Re: 33, Sea Way, Middleton-on-Sea – Ref. M/91/13

Further to our telephone conversation, please find enclosed revised drawings of the proposed Garage extension at the above, drawing numbers 6739/03B and 04.

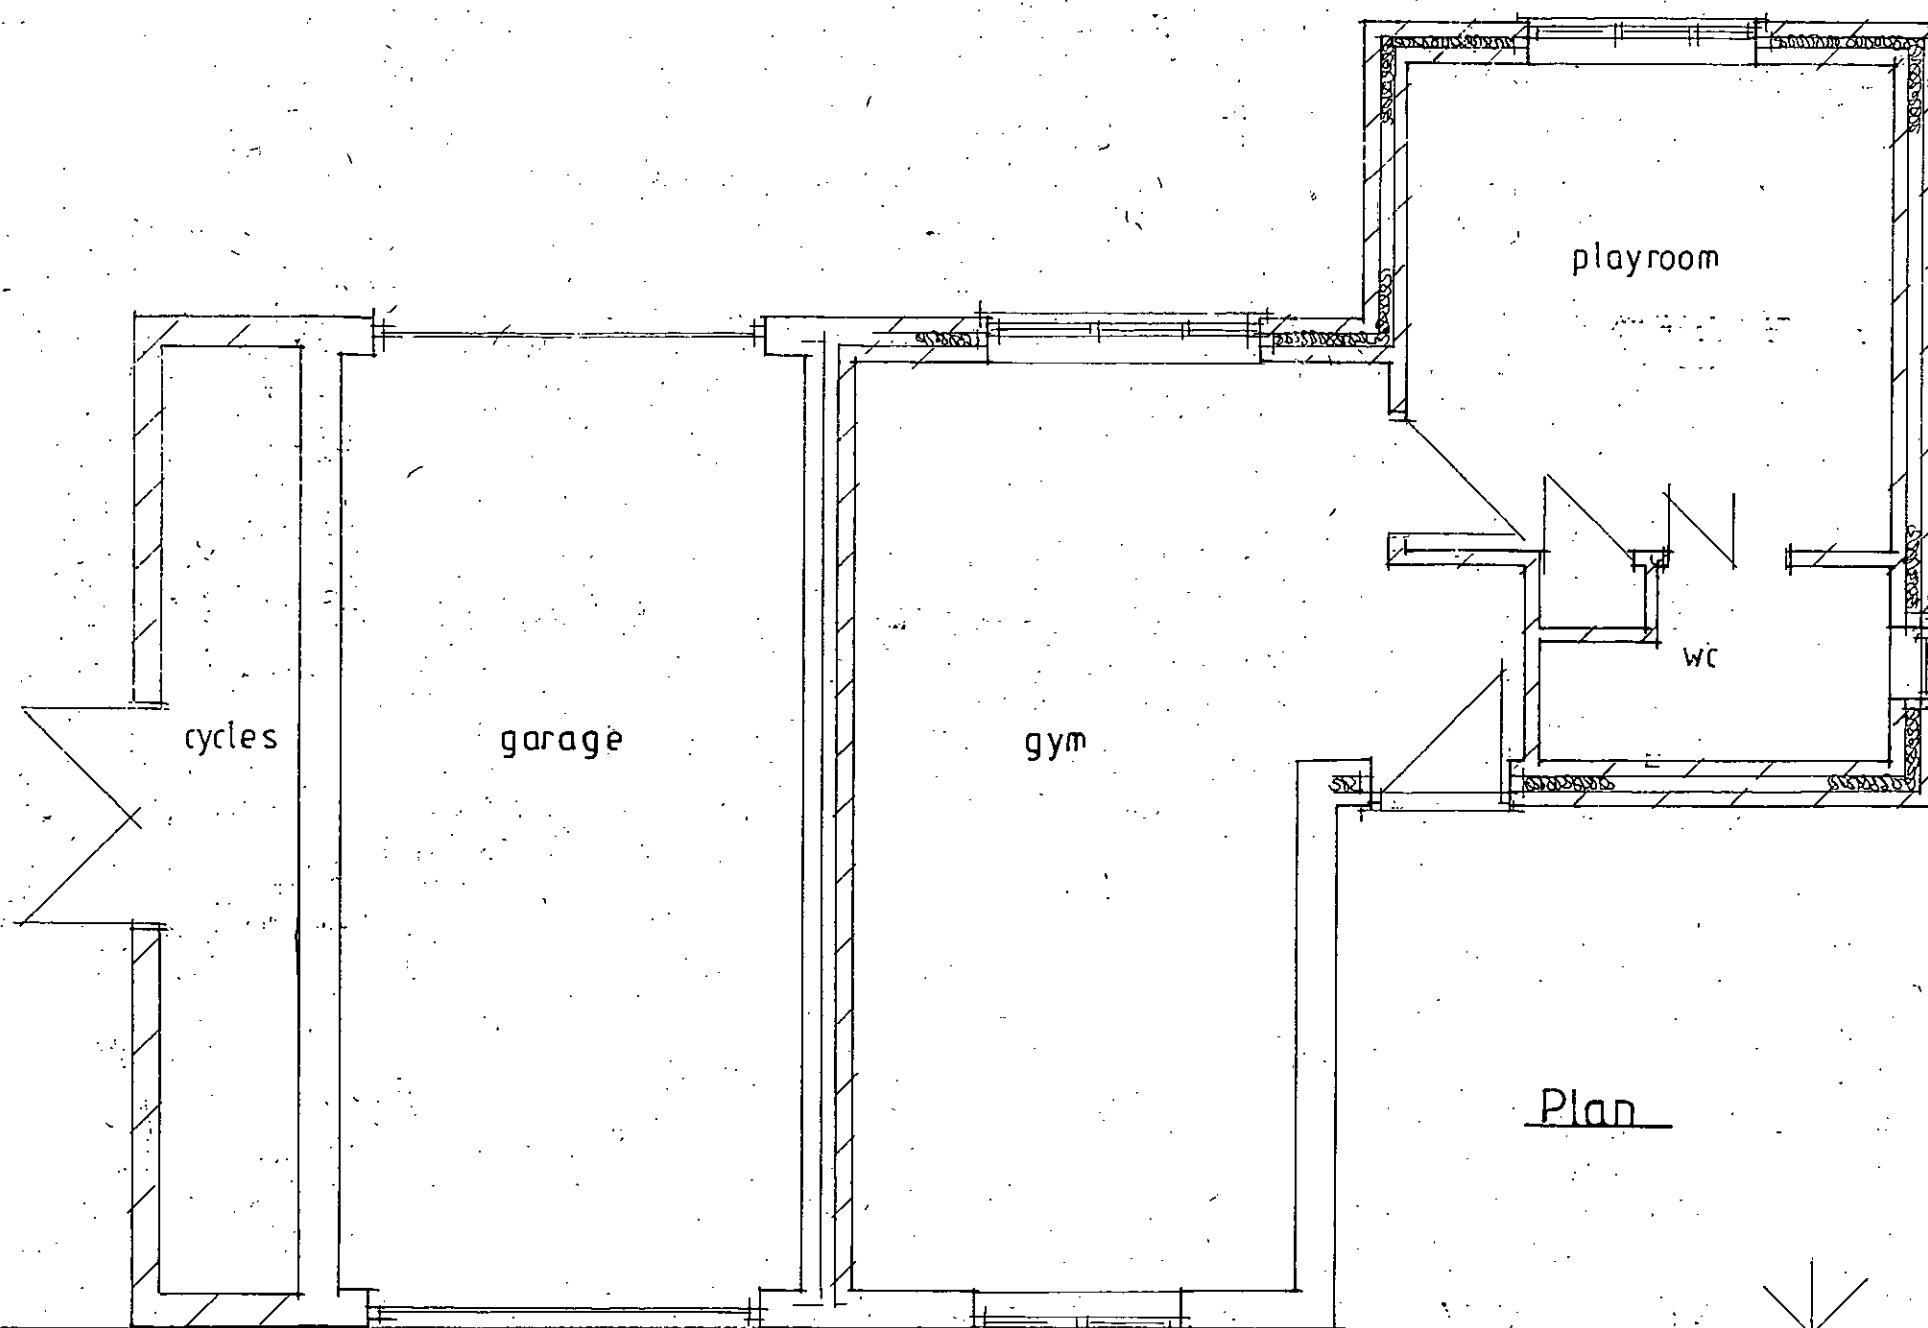
Our Tree Expert, Mr. E.J. Hennessy of E.J. Hennessy Forestry has recommended that the extension is built 3M from the tree, which is a Holm Oak, in order to safeguard its roots. I have therefore amended the proposal to ensure that the extension is built at least 3M from the tree.
